REPORT UPDATE

Application No: BR/93/18/PL

Recommendation Report for Planning Permission

PROPOSAL: Single storey pitch roof side extension, flat roof rear extension with replacement of existing garage with 2 No. metal storage containers on a concrete slab with access ramps.

Title
New Container Store to
replace existing garage

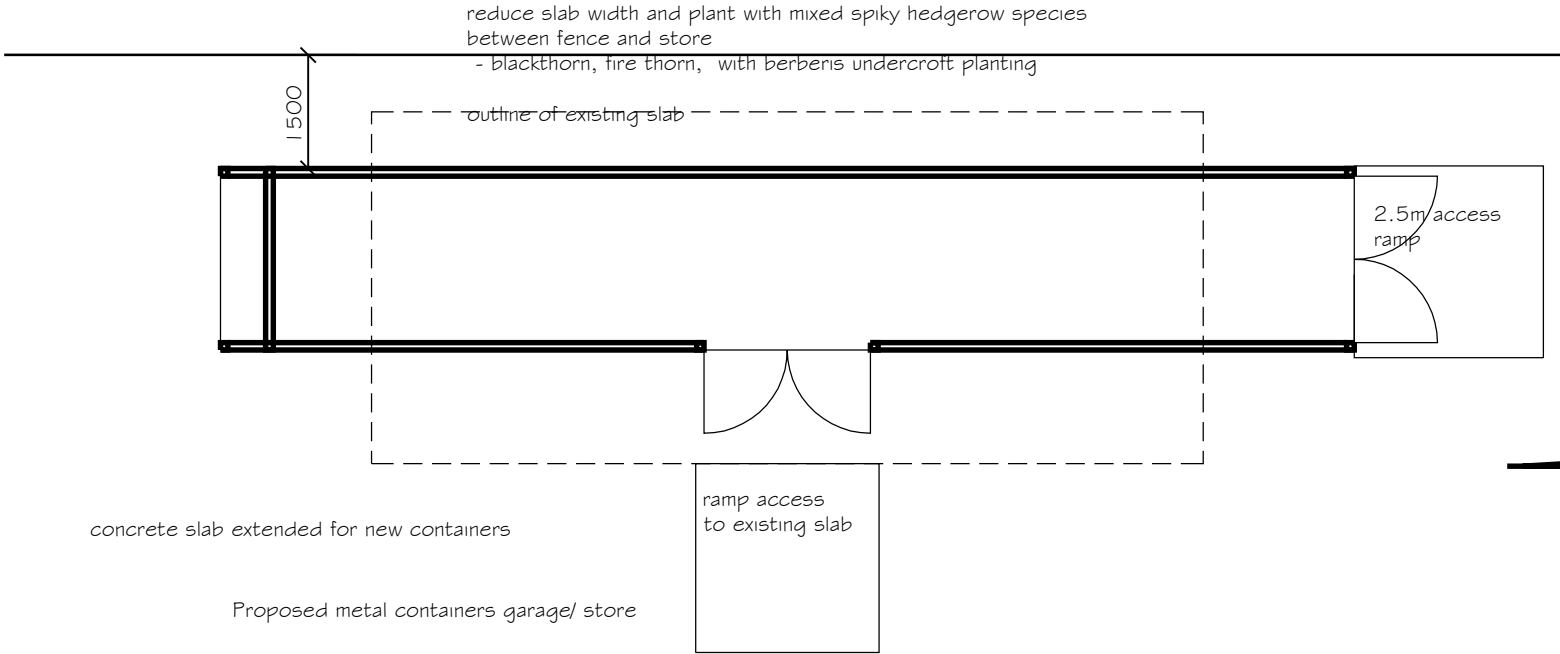
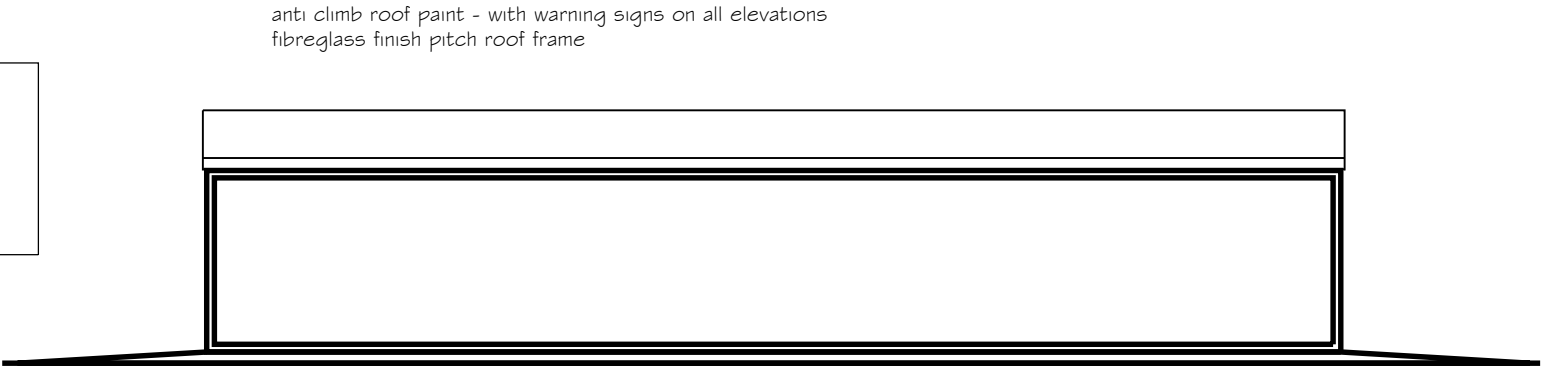
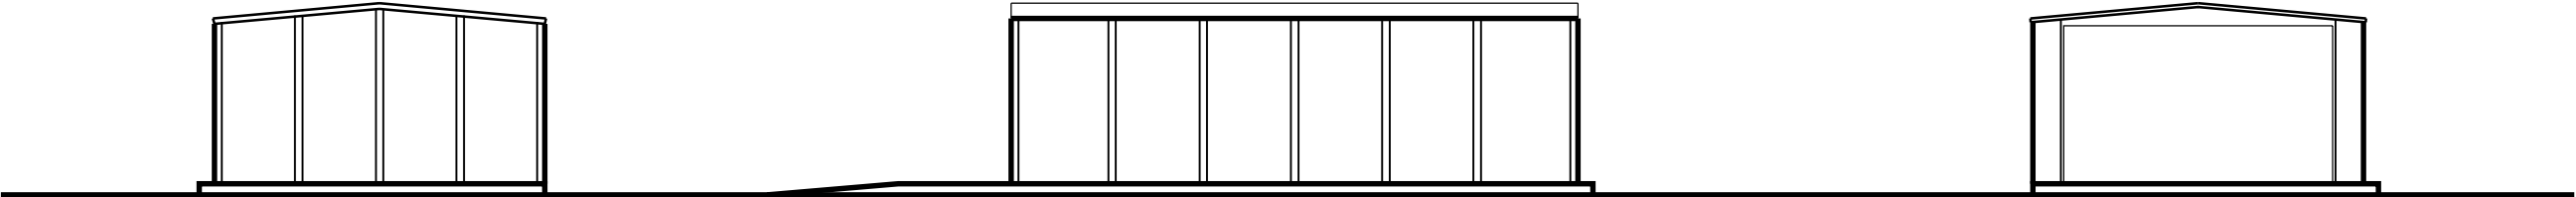
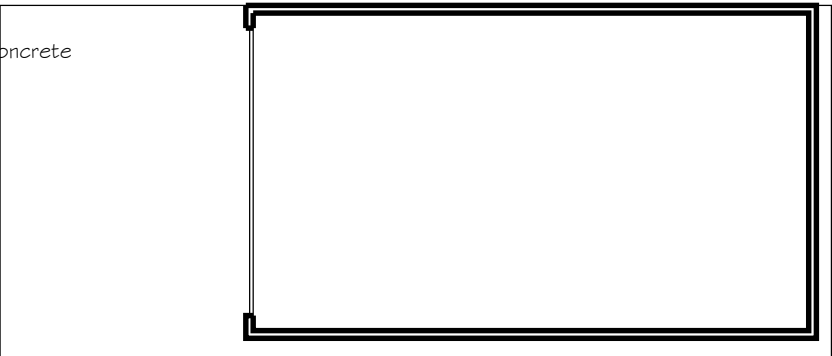
It should be noted that the container is already on site (minus the proposed pitched roof) within the car park and is painted green with brown stripes. The container would feature a pitched roof covered with anti-climb paint to stop antisocial behaviour. The proposed container would have a height of 3.8 metres to the bottom of the concrete base and would be metal in construction. Additionally the proposed container would be sited off the common boundary of adjoining properties by approximately 1.5 metres. While the proposed container would not be of the most outstanding design Officers consider it would not have a detrimental impact on the setting of the wider area.

Amendments have been made to the application whereby one of the proposed containers has been removed and the addition of a pitched roof covered in anti-climb paint is proposed. The plans have been amended so that the container would be sited 1.5m in from the rear boundary of neighbouring properties with spikey tree and shrub planting in the gap between the rear boundary of neighbouring properties. Not all unsociable activity can be stopped in this location but officers consider the measures go a considerable way to restrict the ability to climb on the storage container. Officers consider this could reduce disturbance caused to occupiers of neighbouring properties. Planning should take into account safety and security and where possible have mind to crime prevention. With this in mind, Officers consider that the amendments made would reduce the potential for the proposed storage container to be used to disturb occupiers of neighbouring properties.
